**SSD 6011 - Mixed use residential development within the South West Plot**

**Submission by:**

**Christophorus Susanto**

**21 July 2013**

## Winter Solstice (21<sup>st</sup> June)

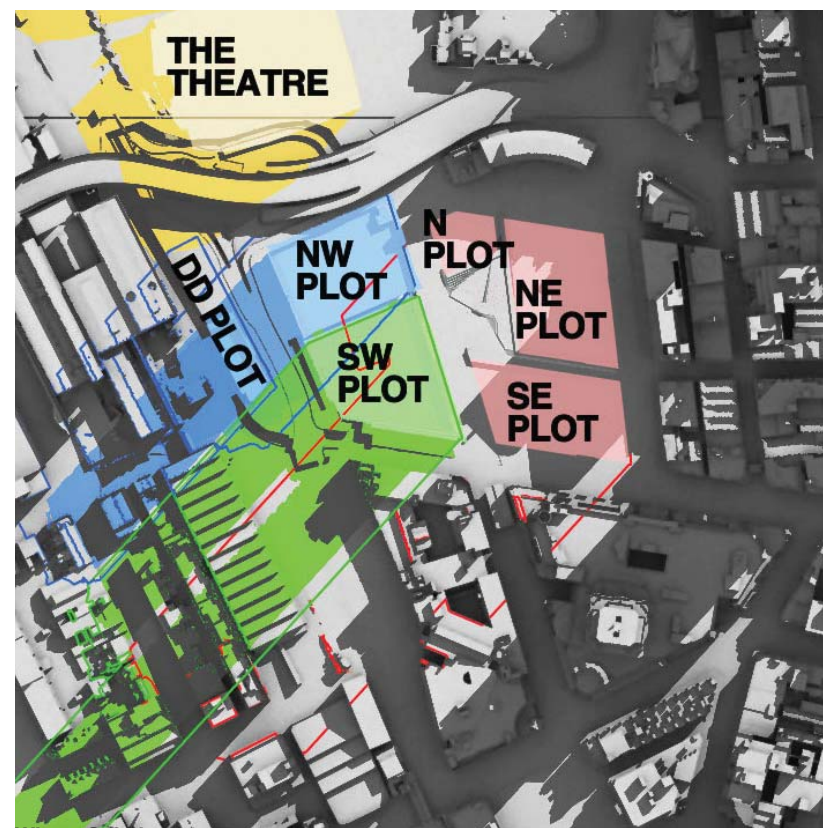
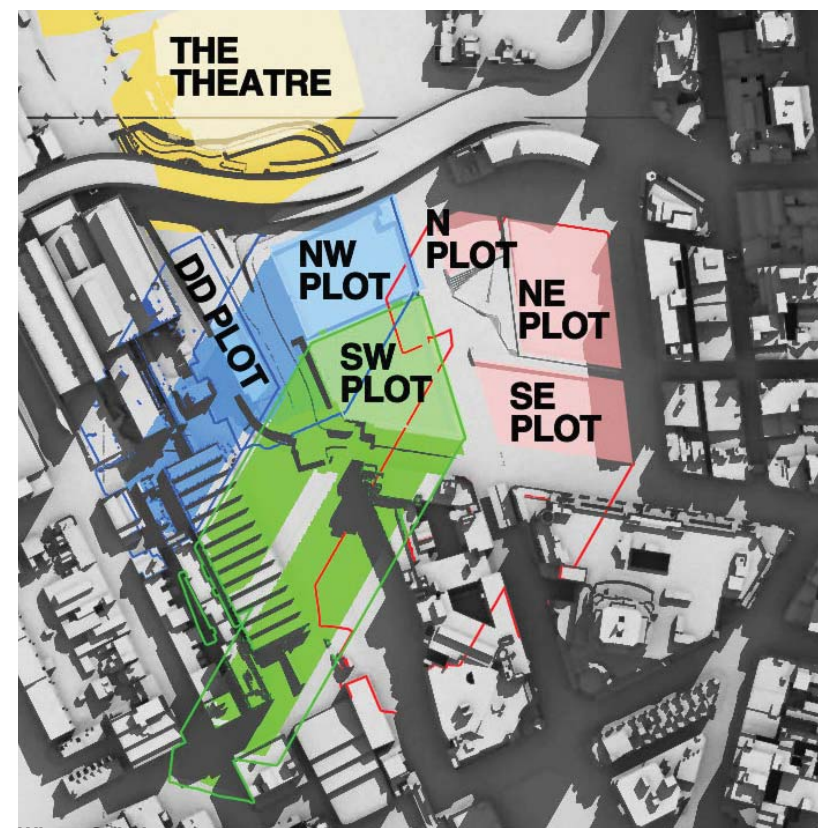
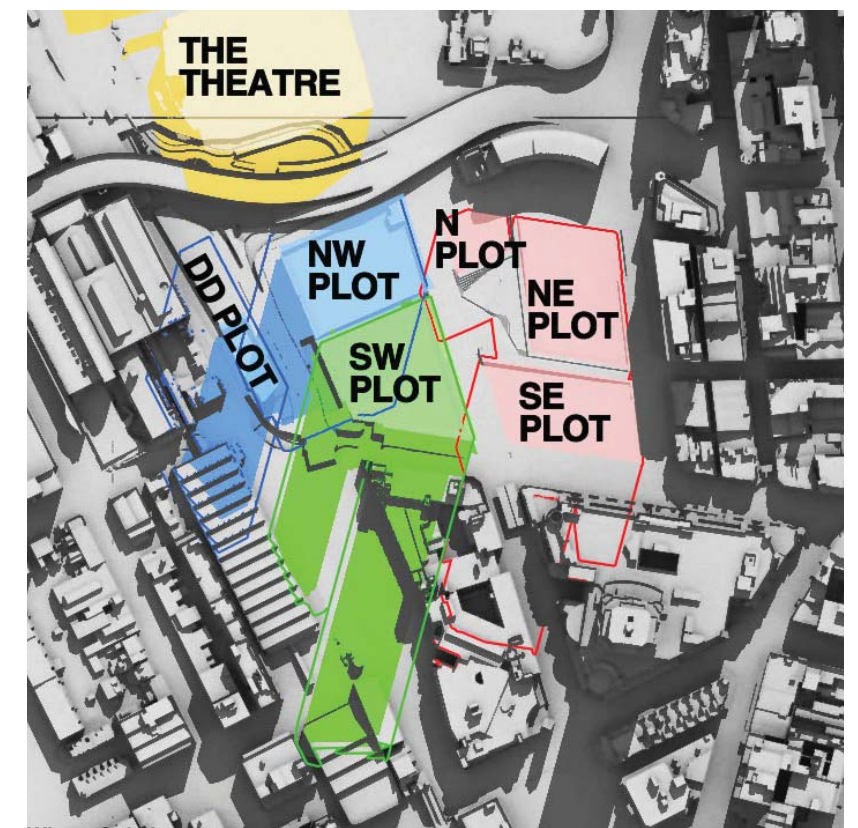
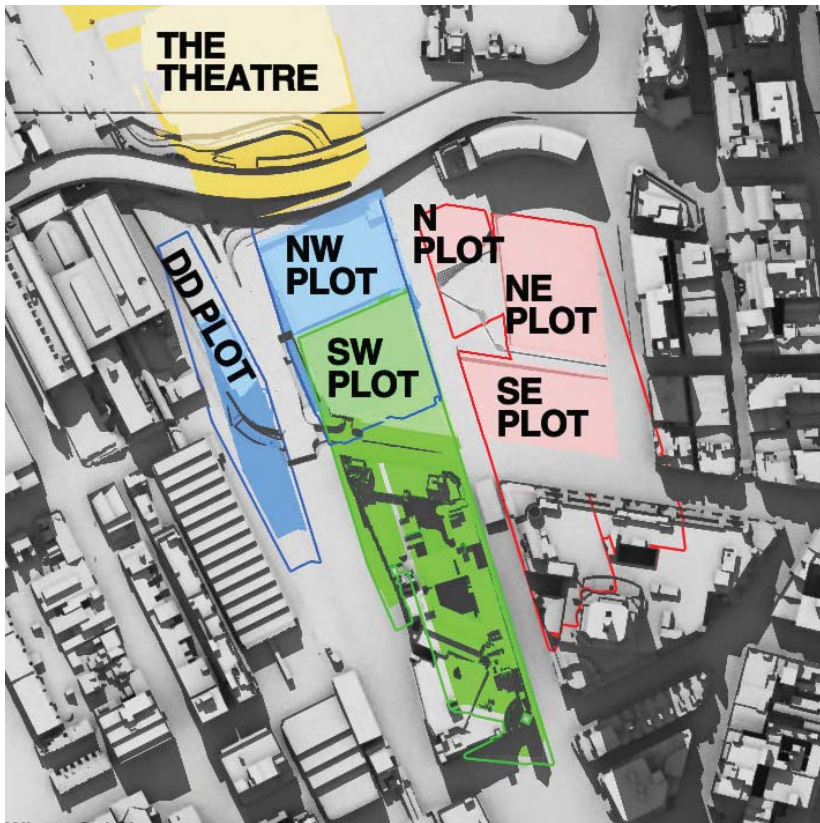
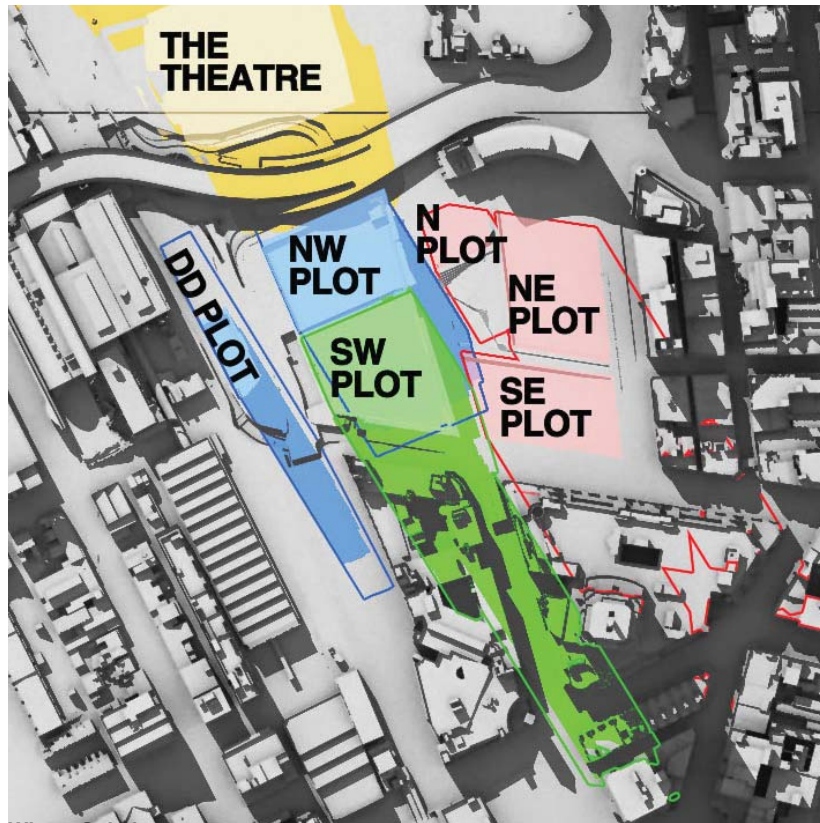
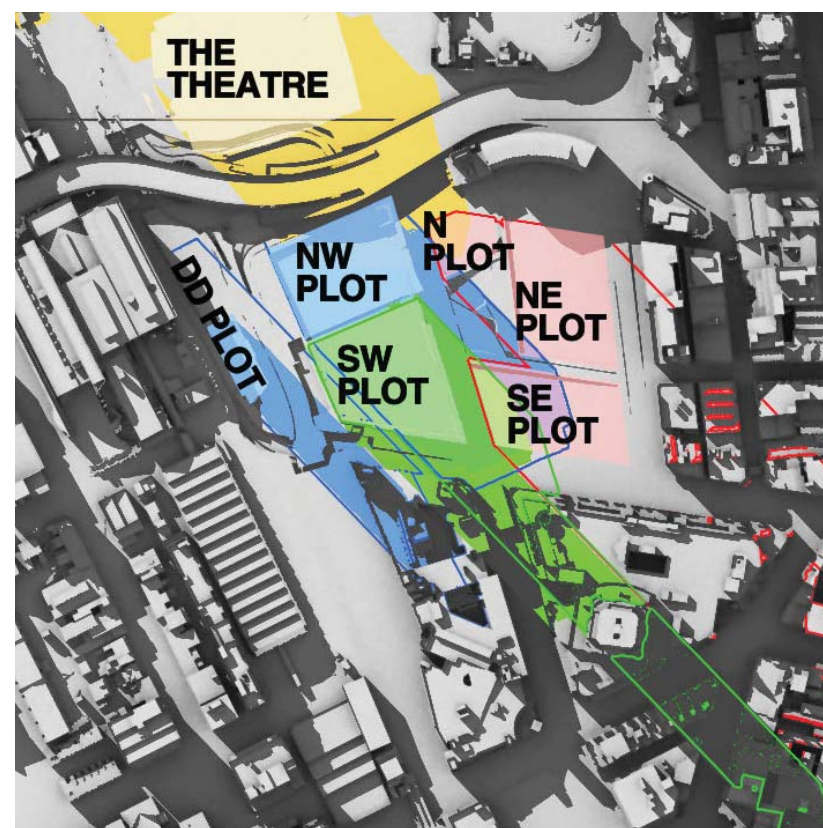
The proponent provides diagrams but fails to discuss the existing shadowing of the west façade of The Peak.

At 9am, 10am and 11am the west façade is totally in shadow due to other parts of The Peak building itself.

At 12pm there is still substantial existing shadowing on the west façade caused by the irregular shape of the west facade.

At 1pm the existing shadowing has been substantially removed, but not totally removed.

It can be concluded that some single aspect apartments on the west façade and some south-west dual aspect corner apartments currently receive less than 2 hours direct sunlight to habitable rooms and 50% of the private open space between 9am and 3pm on 21 June.

By 2pm the existing shadowing has been totally removed, but that is too late to achieve two hours of direct sunlight before 3pm.

At 9am, 10am and 11am the west façade is totally in shadow due to other parts of The Peak building itself.

At 12pm there is still substantial existing shadowing on the west façade caused by the irregular shape of the west facade.

At 1pm the existing shadowing has been substantially, although not entirely, removed. However, overshadowing of lower levels of the west façade by the concept proposal parameter plan shadows for the N,NE and SE plots has already started.

By 2pm the existing shadowing has been totally removed. However, overshadowing of the west façade by the SSDA4 and SSDA5 buildings has appeared and risen further up the west façade than the concept proposal parameter plan shadows for the N,NE and SE plots, which is still present.

At 3pm, the proponent states correctly that 45-45% of the western façade is overshadowed by the SSDA4 and SSDA5 buildings.

It can be concluded that, as a result of combination of the proposed development with existing shadowing of the west façade, some single aspect apartments on the west façade and the south-west dual aspect corner apartments which currently receive less than 2 hours direct sunlight to habitable rooms and 50% of the private open space between 9am and 3pm on 21 June will suffer additional overshadowing. It is beyond our skills to count the number of such apartments. We note that the proponent has made no attempt to do so.

Rather than counting the number of units which will not meet the DCP guidelines, the proponent attempts to trade-off direct sunlight at 4pm for lack of direct sunlight during the period 9am to 3pm. There is no provision in the DCP guidelines for such a trade-off.
